Application no: **3/2022/0676**

Address: **Land adjacent to Radcliffe Farm Lower Road Longridge PR3 2YL**

Proposal: **Erection of hay storage and drying building.**

The Local Highway Authority have viewed the plans and highway related documents and have the following comments to make:

Drawing Title
 PROPOSED SITE PLAN

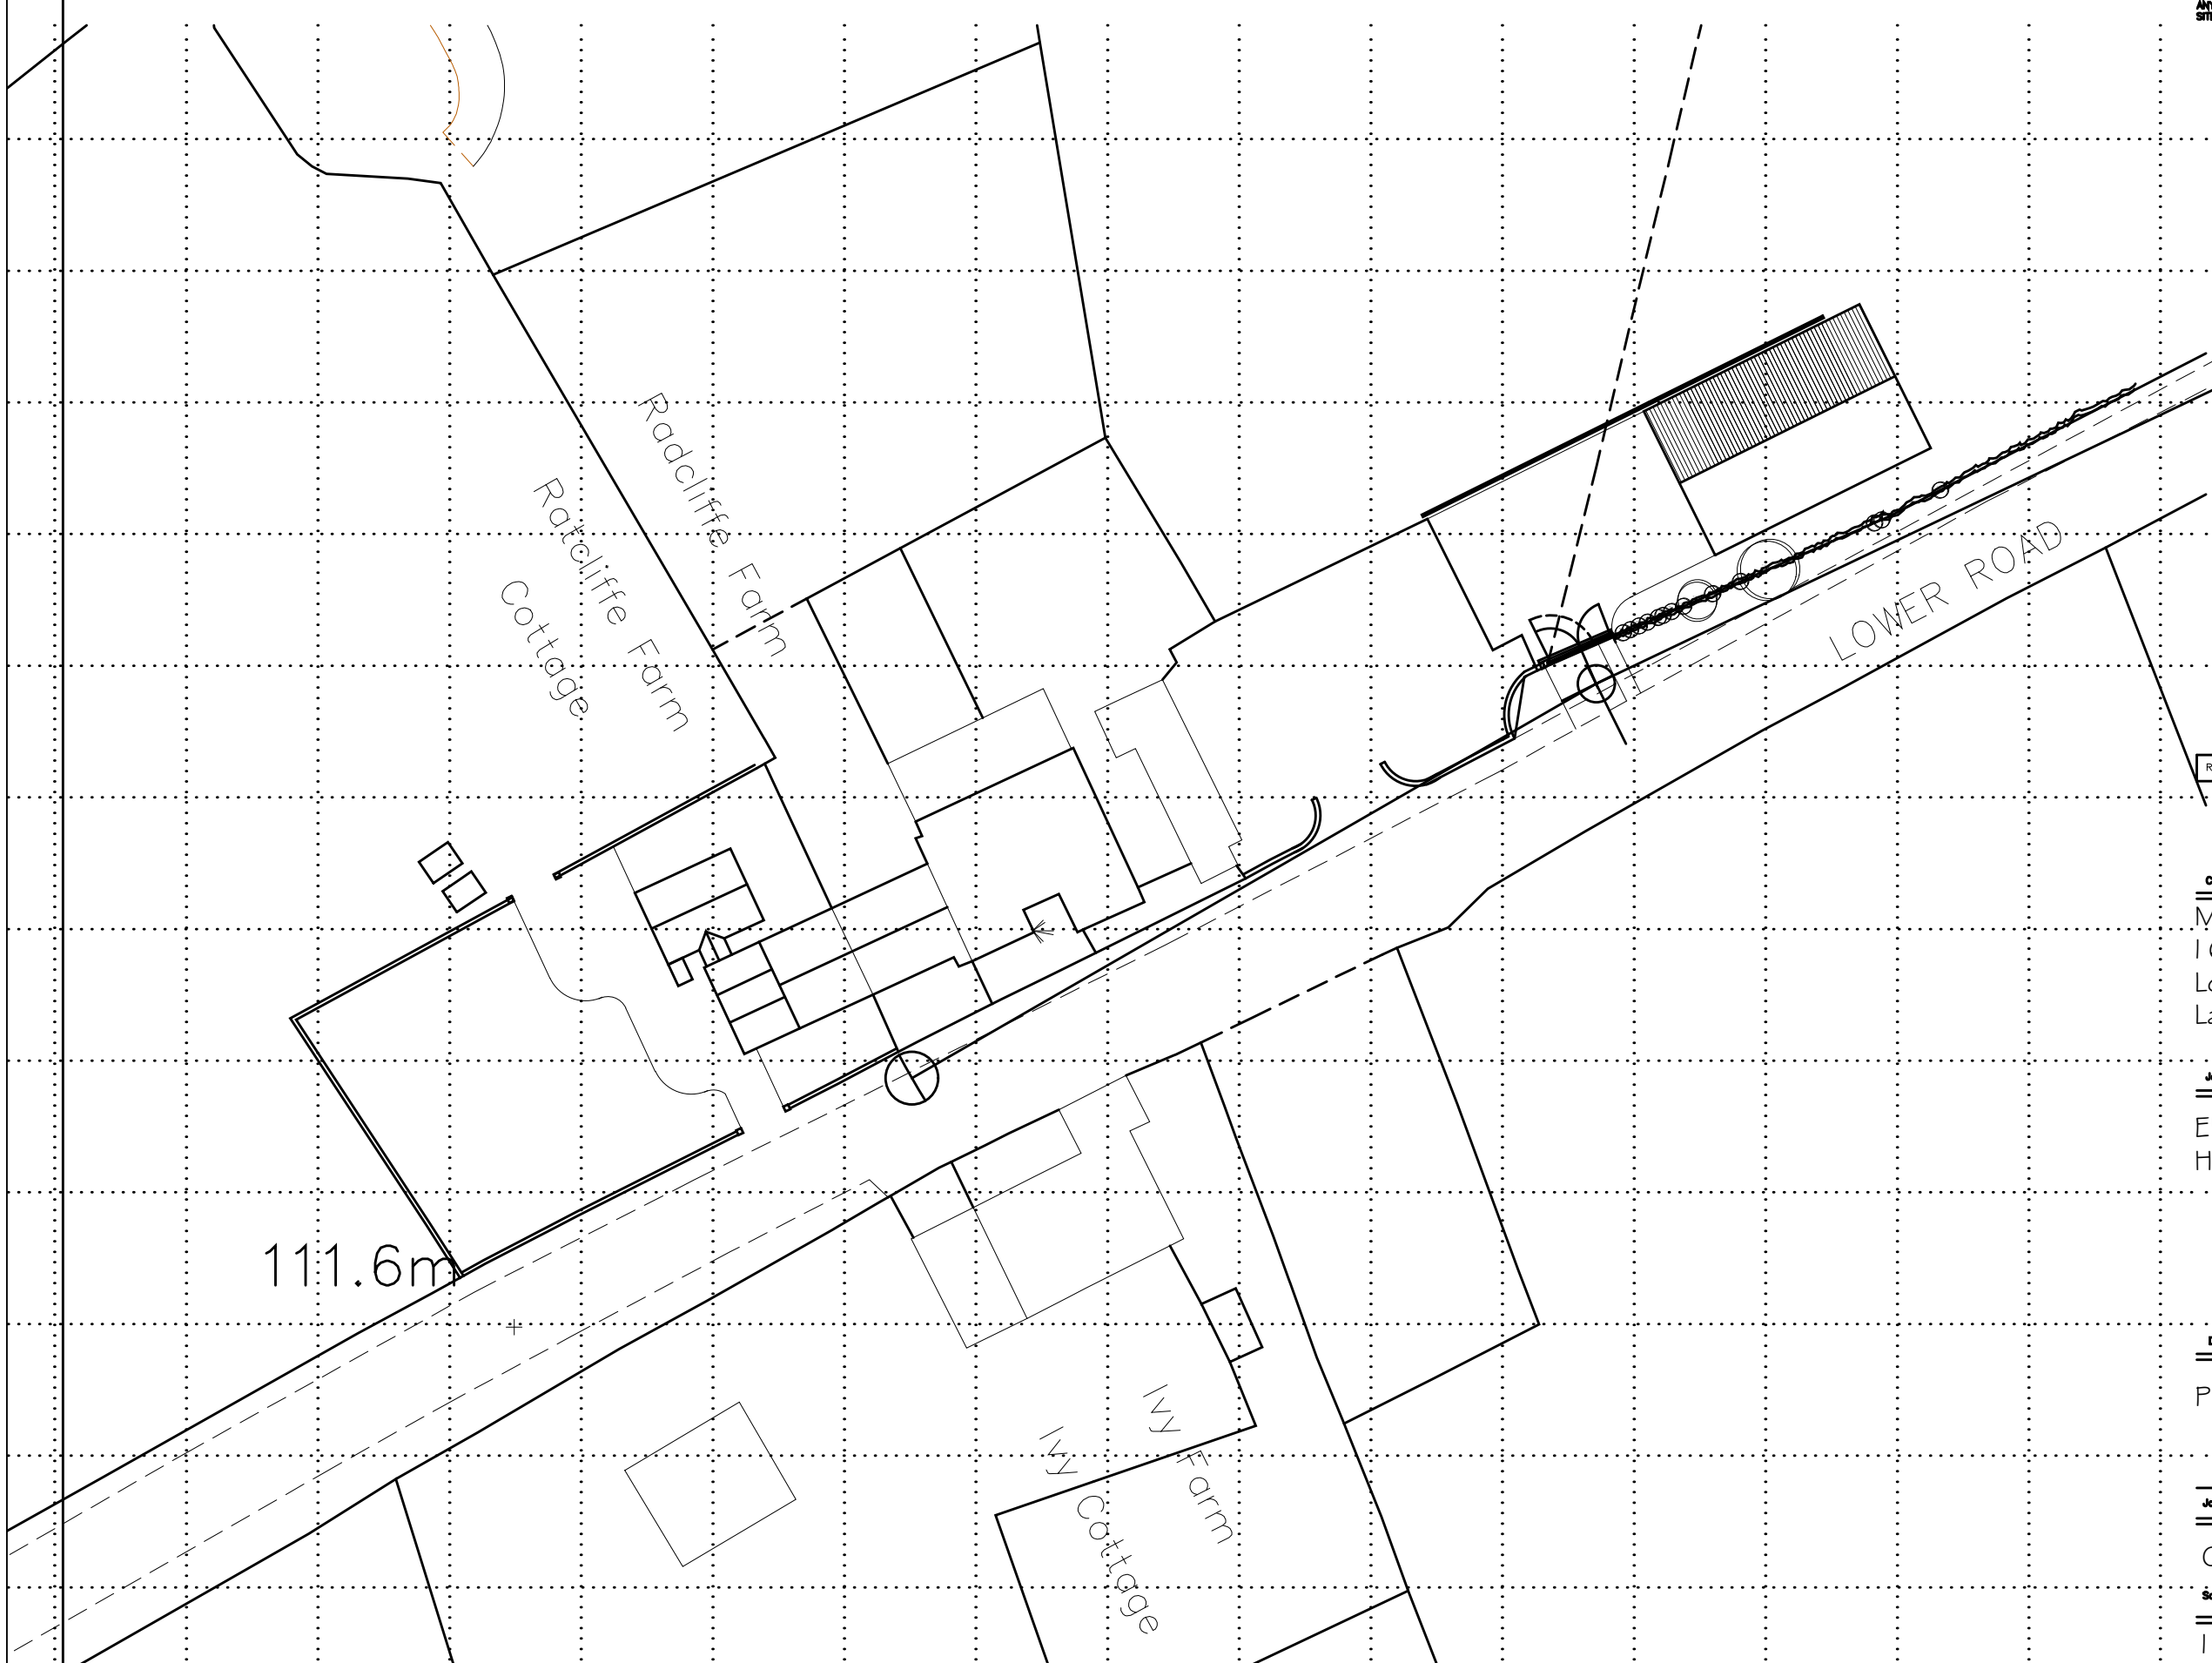
The LHA have reviewed ALH drawing number 10 titled "Proposed Site Plan" and have no comments to make regarding the use of the access to serve the proposed building. This is because the proposal will utilise the same access as was approved following application reference 3/2014/0874 which was approved to serve the hay storage and drying building, alike this application. Therefore, the LHA have no objection to the proposal.

The LHA will however, condition that the access is re-surfaced due to the intensification of use of the access following the proposal.

The LHA also inform the Applicant to be aware of Public Footpath 3-2-FP21 which uses the site access and the adjoining field.

1. The development hereby permitted shall not be occupied until such time as the access drive (and any turning space) has been surfaced with tarmacadam, or similar hard bound material (not loose aggregate) for a distance of at least 5 metres behind the highway boundary and, once provided, shall be so maintained in perpetuity.

2. The surface water from the approved driveway should be collected within the site and drained to a suitable internal outfall. Prior to commencement of the development details of the drainage strategy shall be submitted to and approved in writing by the Local Planning Authority. The scheme shall be implemented in accordance with the approved details.
